Drainage Assessment - Event Parking Area.

50 Peter Brock Drive, Eastern Creek,
NSW

P2108122JR02V01

April 2021

NOT TO SCALE

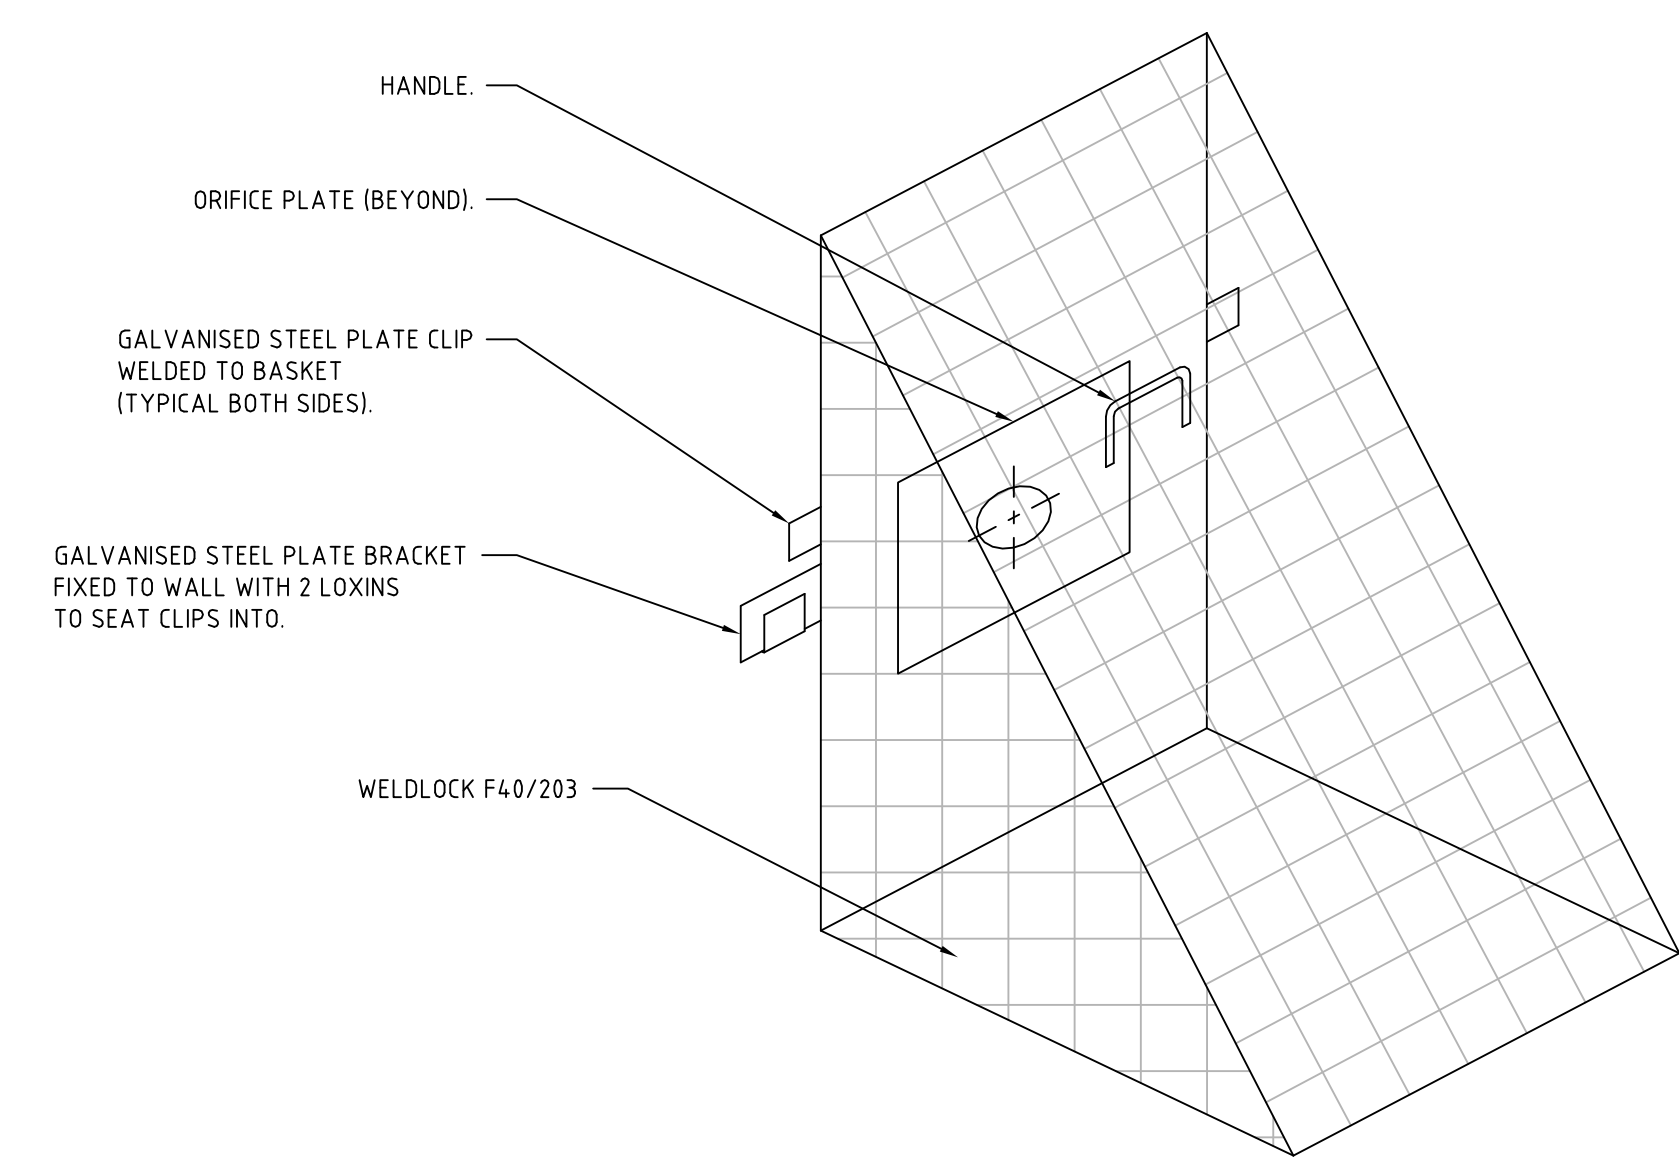
RFI Issue	Response / Comment
7.4 On-Site Detention <i>Given that gravel or bitumen sealing impacts on the previously existing impervious fraction at the subject site, impacts of increased runoff should be managed using a suitable on-site detention system designed in accordance with the Council-designated detention rate of 455 m³ per hectare or other suitable method acceptable to Council. The design of the system to be prepared by the Engineer for further consideration.</i>	OSD has been provided for the Event Parking Area in accordance with BCC's required rate of 455 m³/ha by following BCC's deemed to comply spreadsheet. Refer to Section 4 for further details.

OSD storage has been designed in accordance with BCCs deemed to comply spreadsheet tool. The site requires approximately 240 m³ for the 50% AEP storm and 365 m³ for the 1% AEP storm. Refer to Attachment C - MA planset P2108122PS01 drawing PS01-E100 for the basin location and drawing PS01-E200 for basin details.

BIORETENTION BASIN PLAN
SCALE 1:100

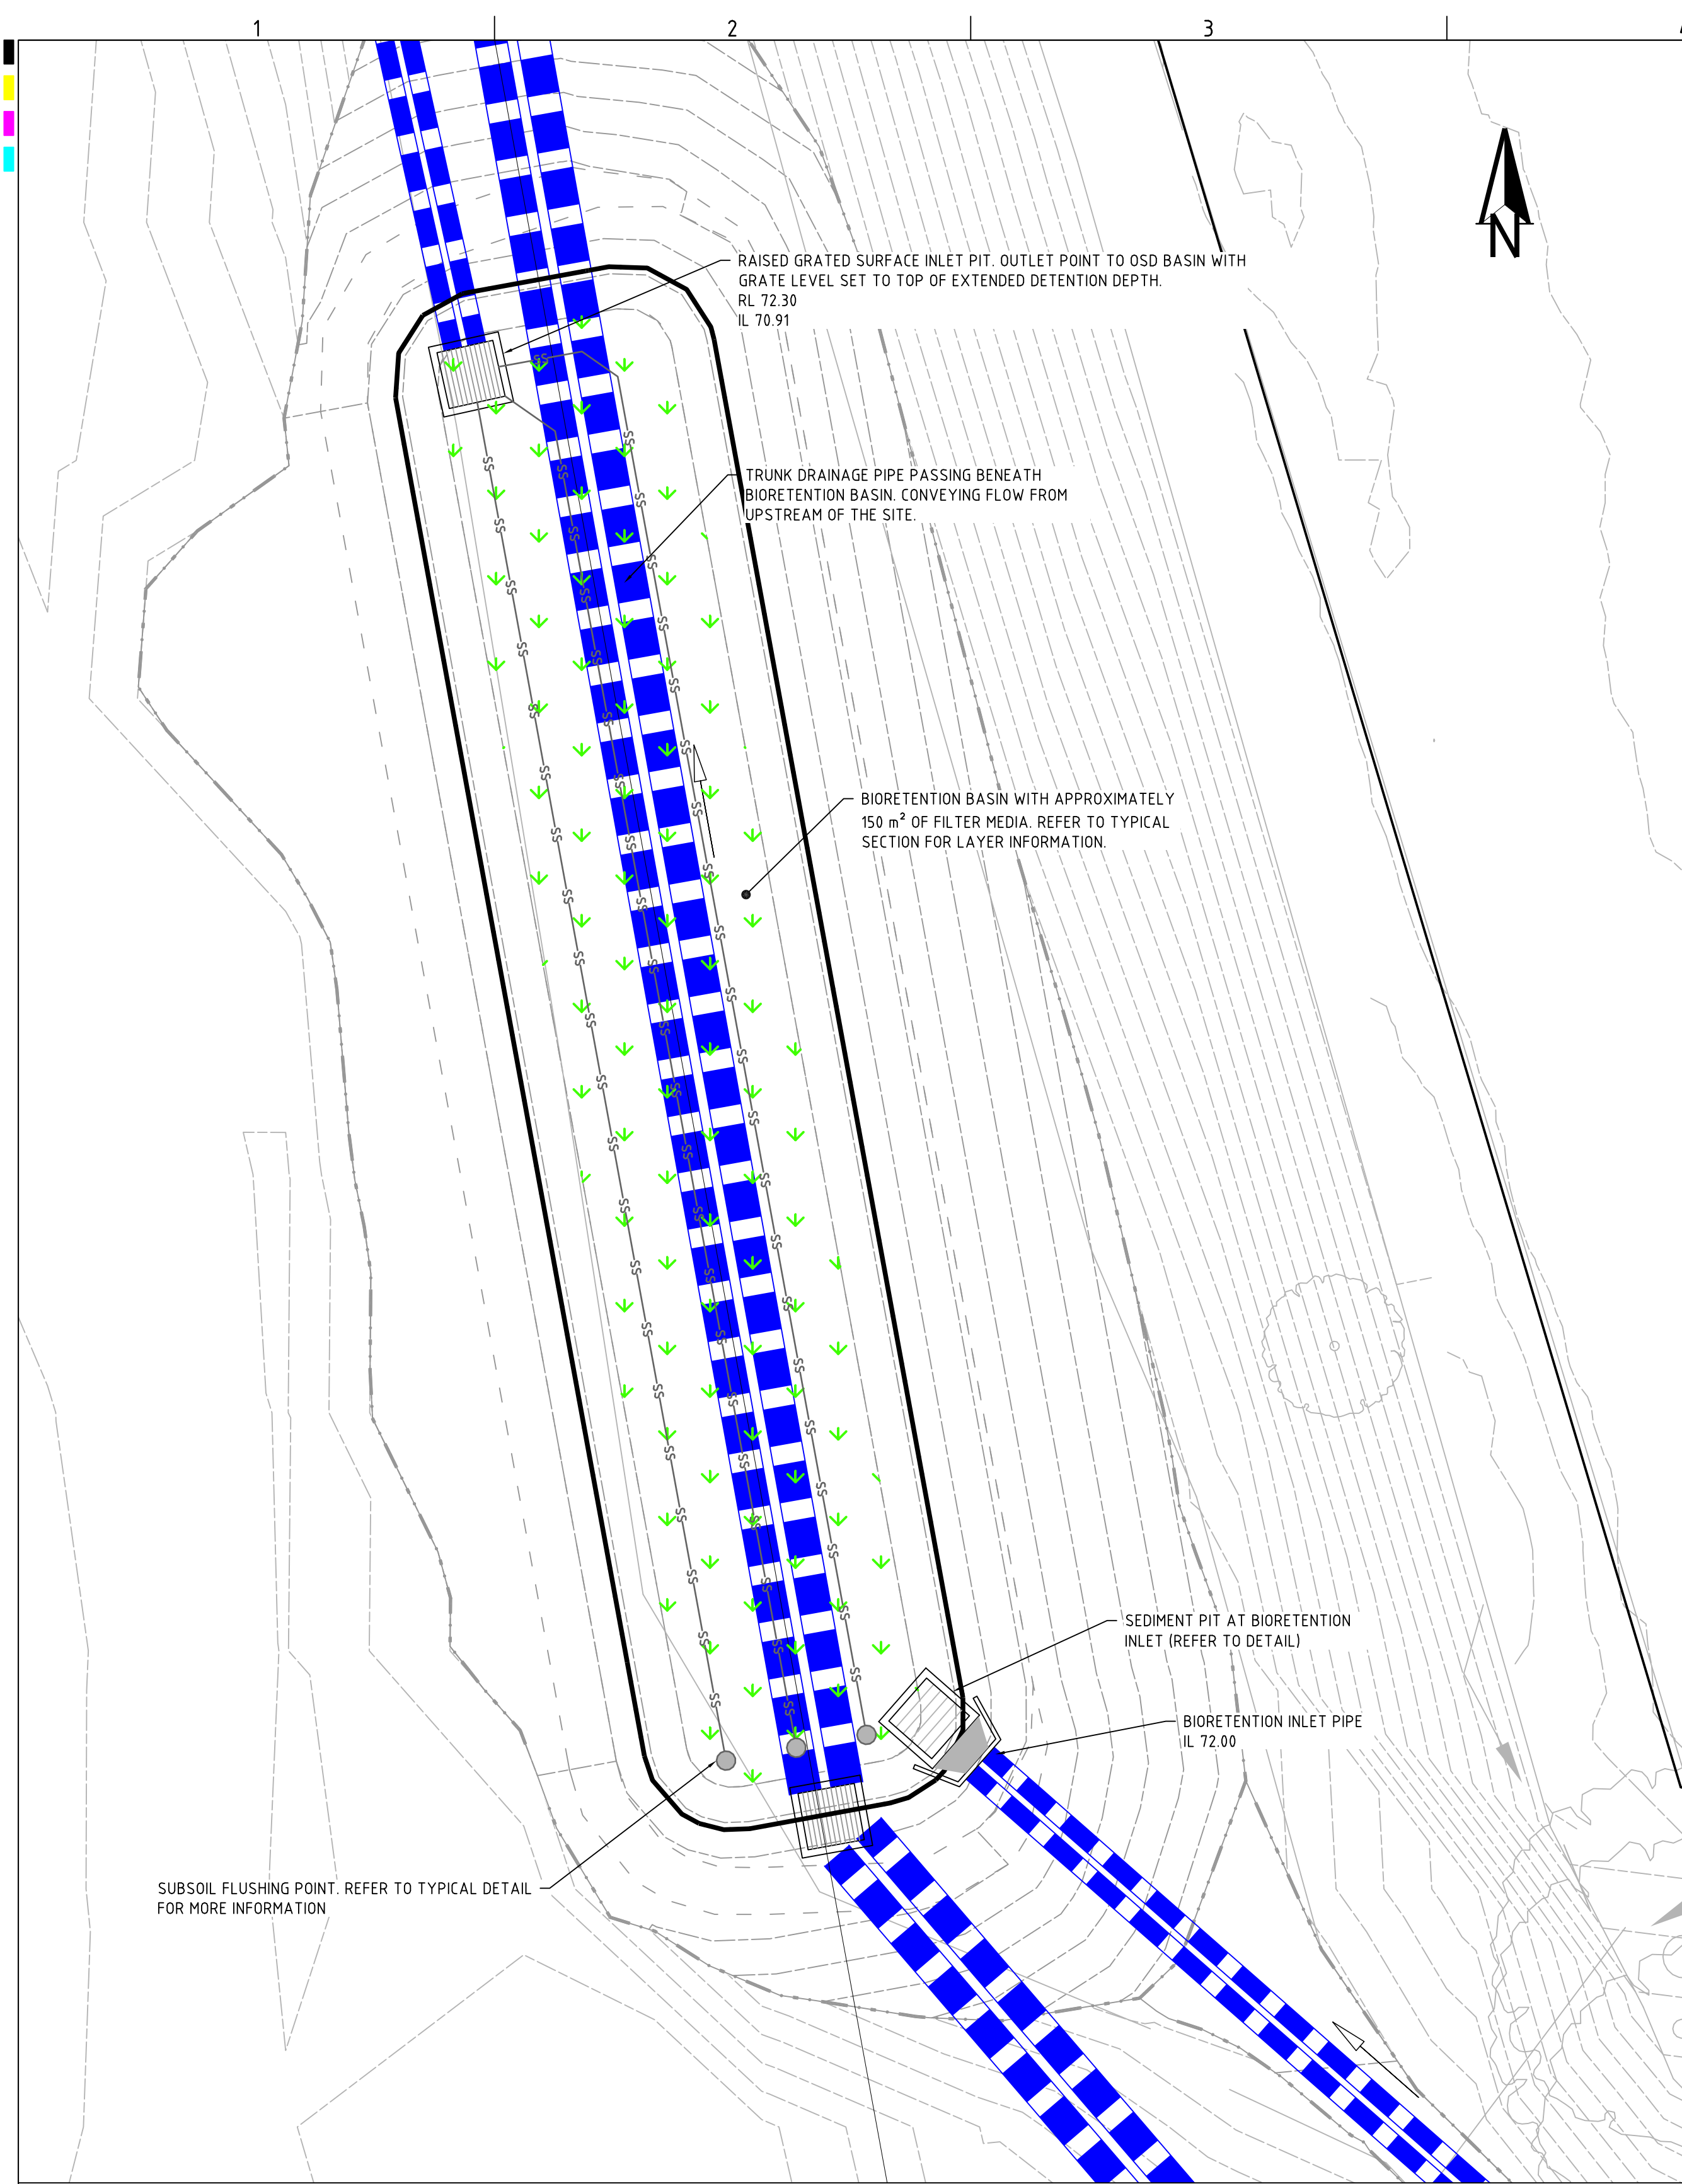
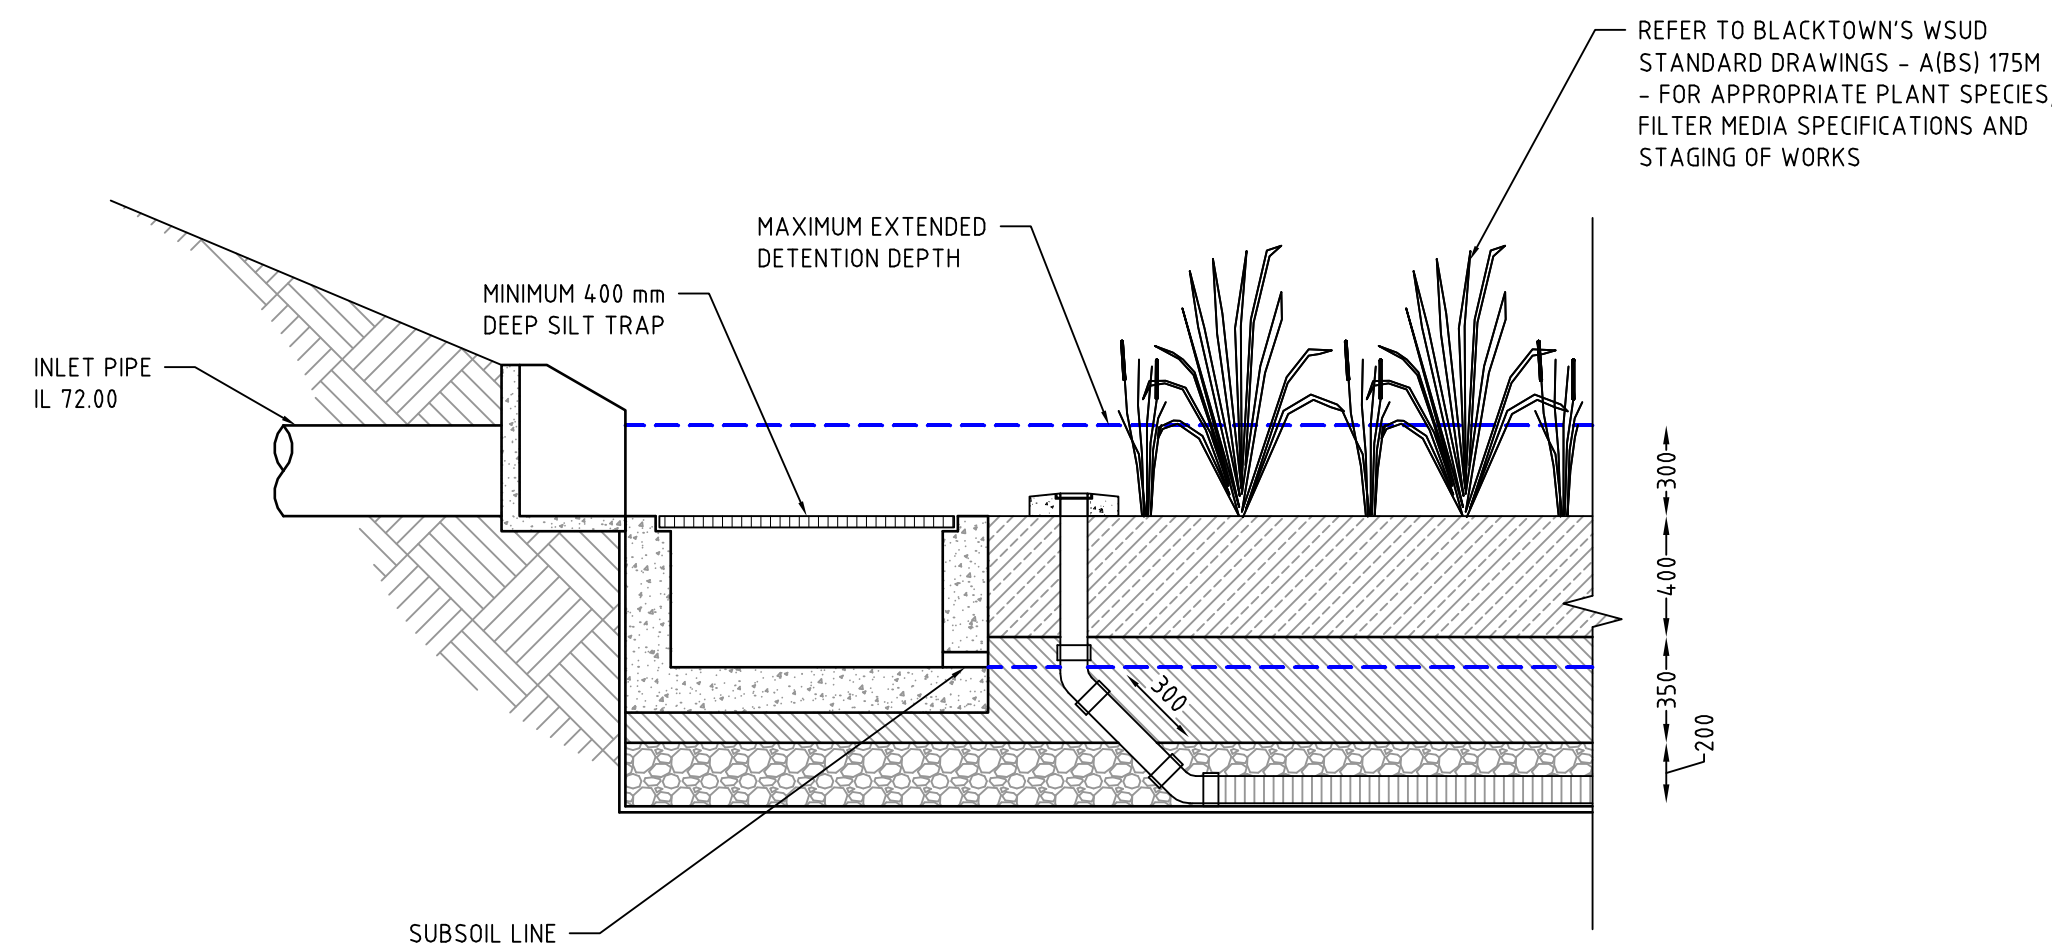
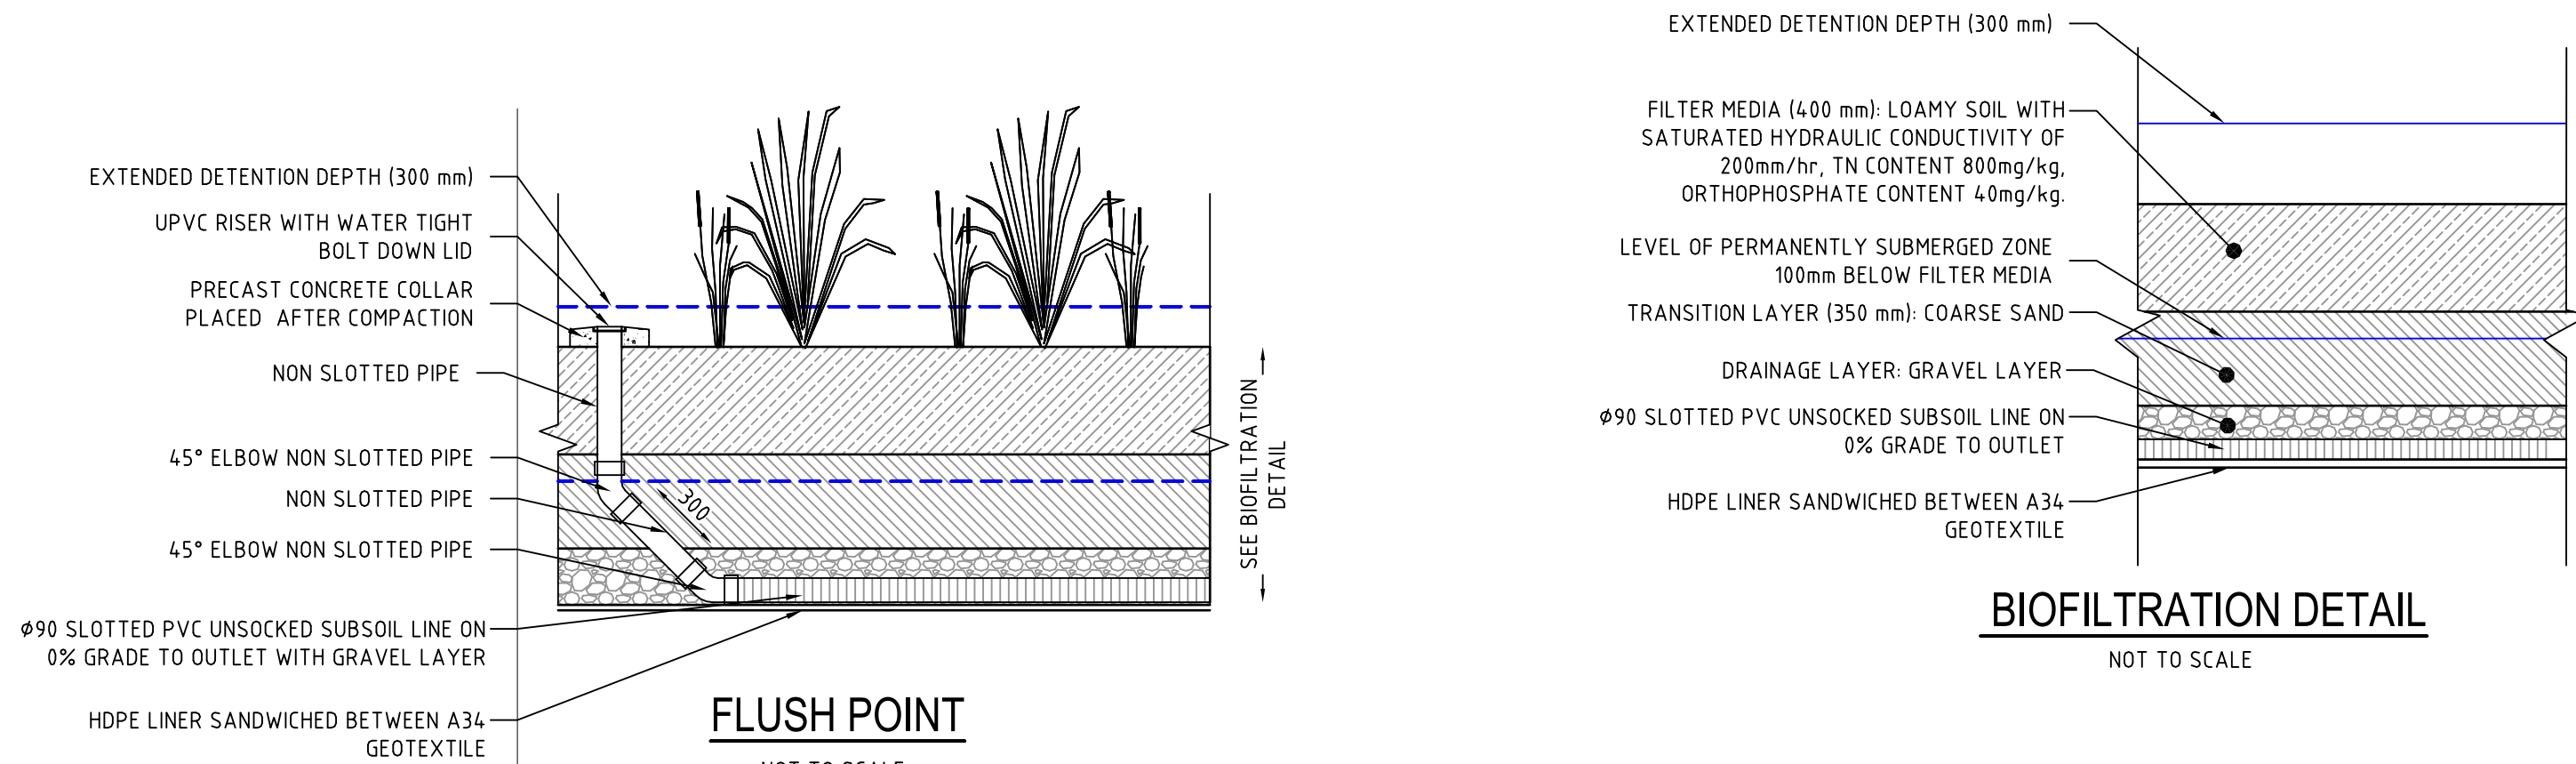
7.5 Water Quality <i>Having regard to changes in surface finish, a water quality treatment system is to be designed by the Engineer in accordance with Council's MUSIC water quality conceptualisation model and submitted for further consideration.</i>	A water quality system is included within the design of the drainage system for Event Parking Area in accordance with BCC's MUSIC guidelines to treat the pollution generated from the changes in surface finished proposed by the development. Refer to Section 2 for further details.

A bioretention basin is proposed for the site, providing tertiary treatment removing pollutants via filtration, adsorption and biological uptake. Refer to MA planset P2108122PS01 drawing PS01-E100 for the basin location and drawing PS01-E201 for basin details.
